**M3 Junction 9 Improvement Scheme – TR010055**

**Reference:** M3J9-EIA064

For Deadline 6 (D6), the South Downs National Park Authority (SDNPA) would like to make the following submissions including attached at Appendix A – response to ExQ3.

**Engineering Sections at 20m Intervals (Reference REP5-003)**

SL-23 CH-3440.000
Ch:3440.00
A34
SOUTHBOUND

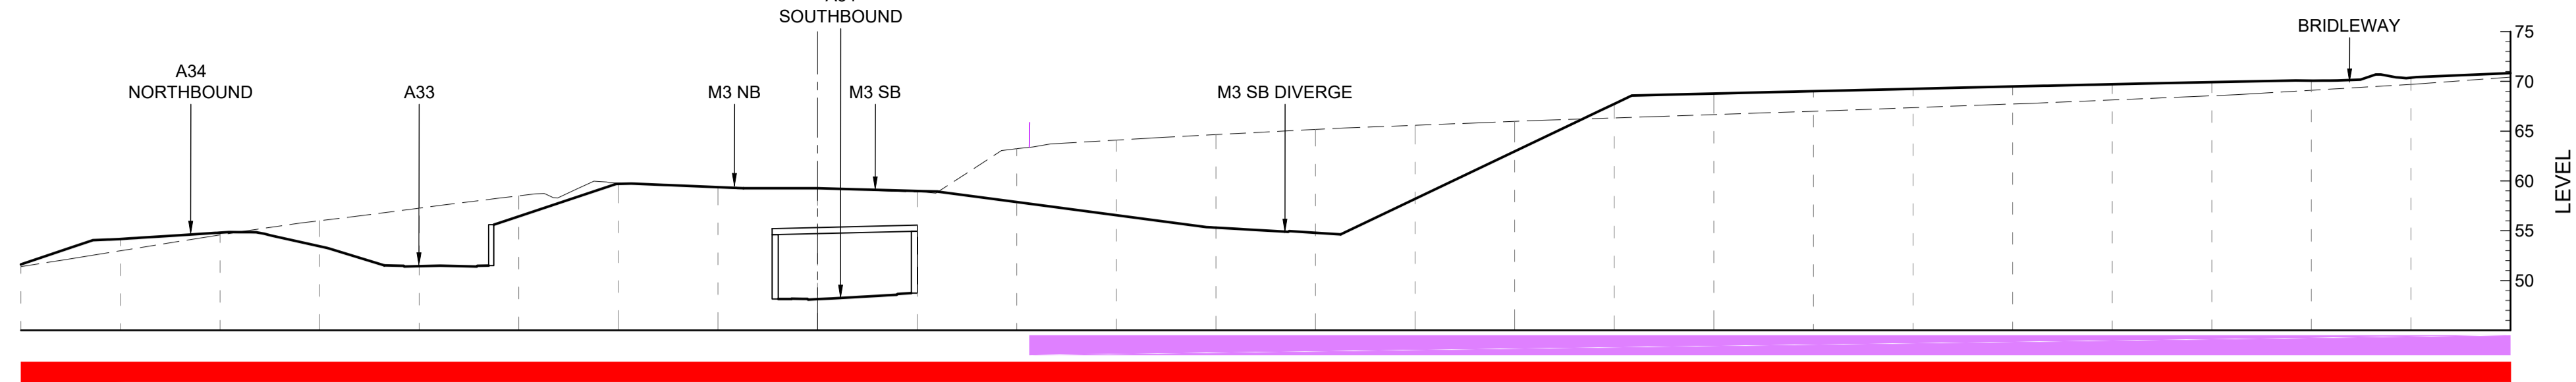
The cross sections provided by the Applicant (reference REP5-003) do enable a better understanding of the effects of the scheme on the topography of the South Downs National Park (SDNP). In the absence of data related to levels the SDNPA has measured areas of maximum cut and fill and has the following observations:

- Significant areas of fill often exceed the maximum 3m stated by the Applicant at ISHI and not just in the region of the ‘false cutting’. For example, from Ch30000 to Ch32000 maximum fill within the SDNP ranges from 3m in depth to 7m (Ch3080).
- The sections from Ch3200 to Ch3900 illustrate how the existing landform of the SDNP will be lost first through cutting and replacement with highways infrastructure and then through fill which will create a new and uncharacteristic landform which will be occupied by highways infrastructure.
- The sections graphically illustrate the permanent loss of the existing landform which the SDNPA considers results in permanent harm.
